Rezoning Transportation Analysis

Petition Number: #2022-161

Revision Log:

Date	Description
02-23-23	First Review (PDM)
04-20-23	Second Review (PDM)

SHEET NO.	SHEET NAME
1 of 3	CONCEPTUAL SITE PLAN
2 of 3	TECHNICAL DATA
3 of 3	MASTER PLAN

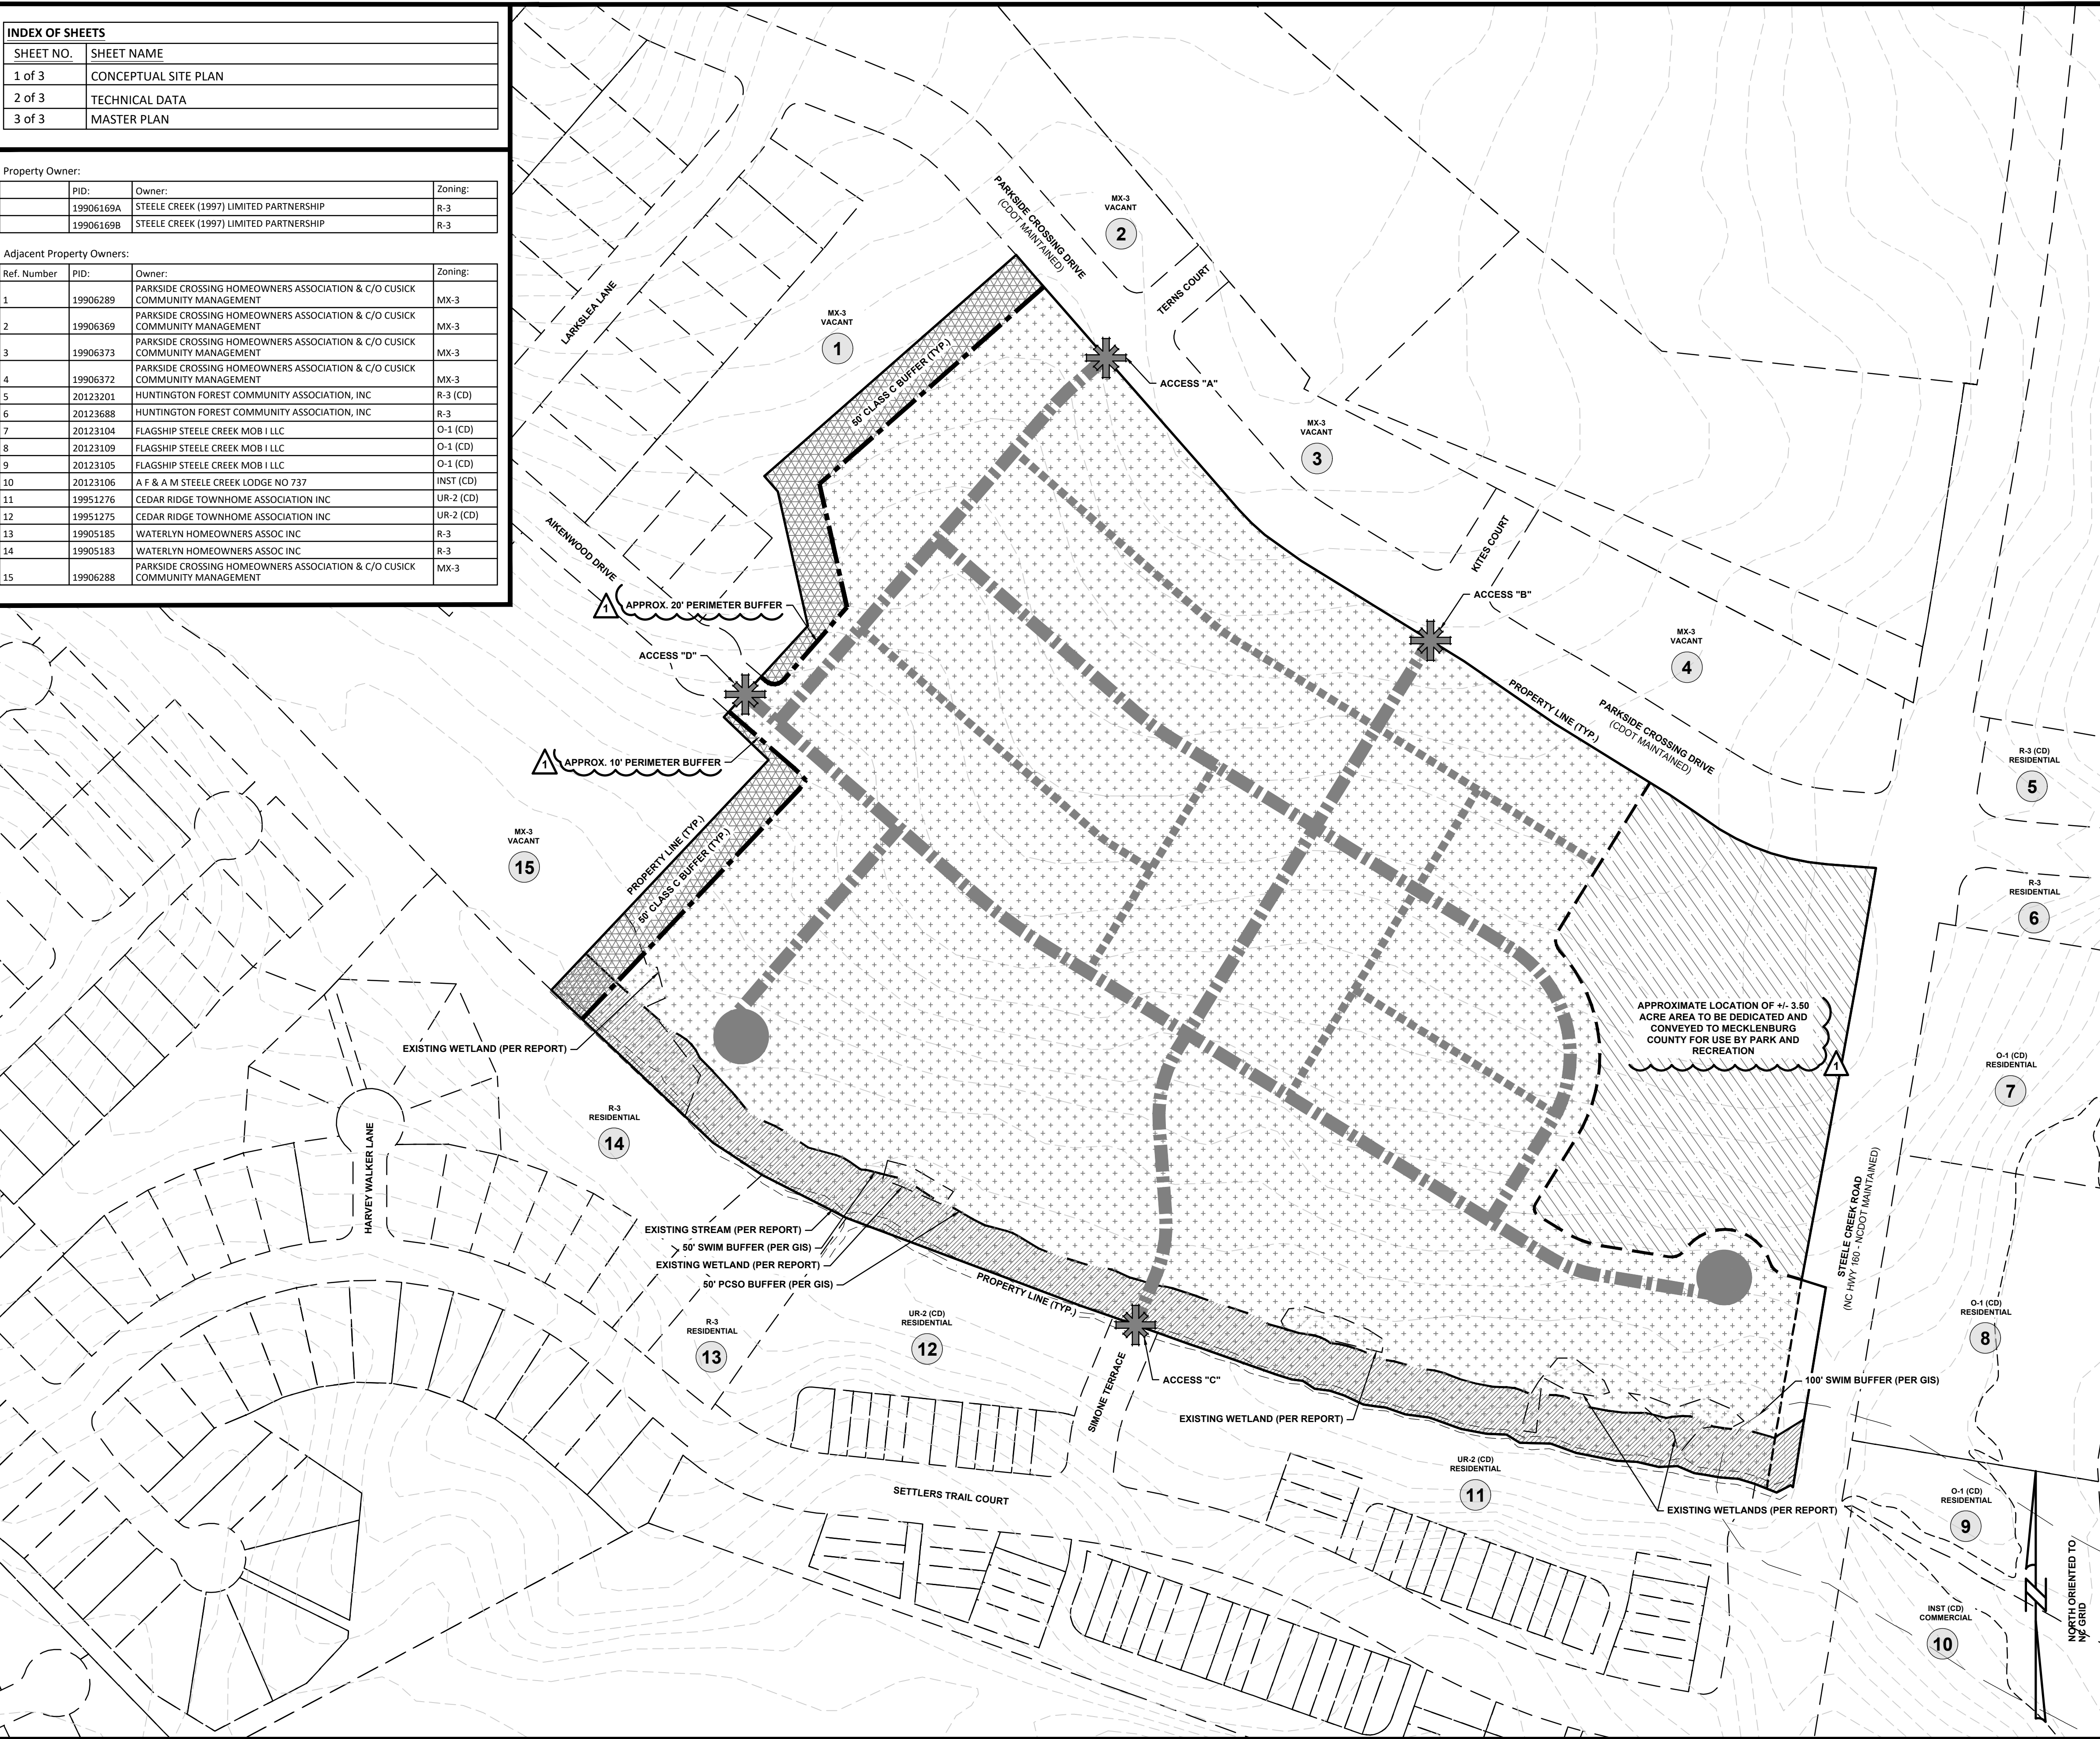
Update to Comment 4.20.2023: Steele Creek Road is a major thoroughfare and requires a minimum of 50ft of ROW dedication.

Update to Comment 4.20.2023: Show proposed road extension tying into Access A.
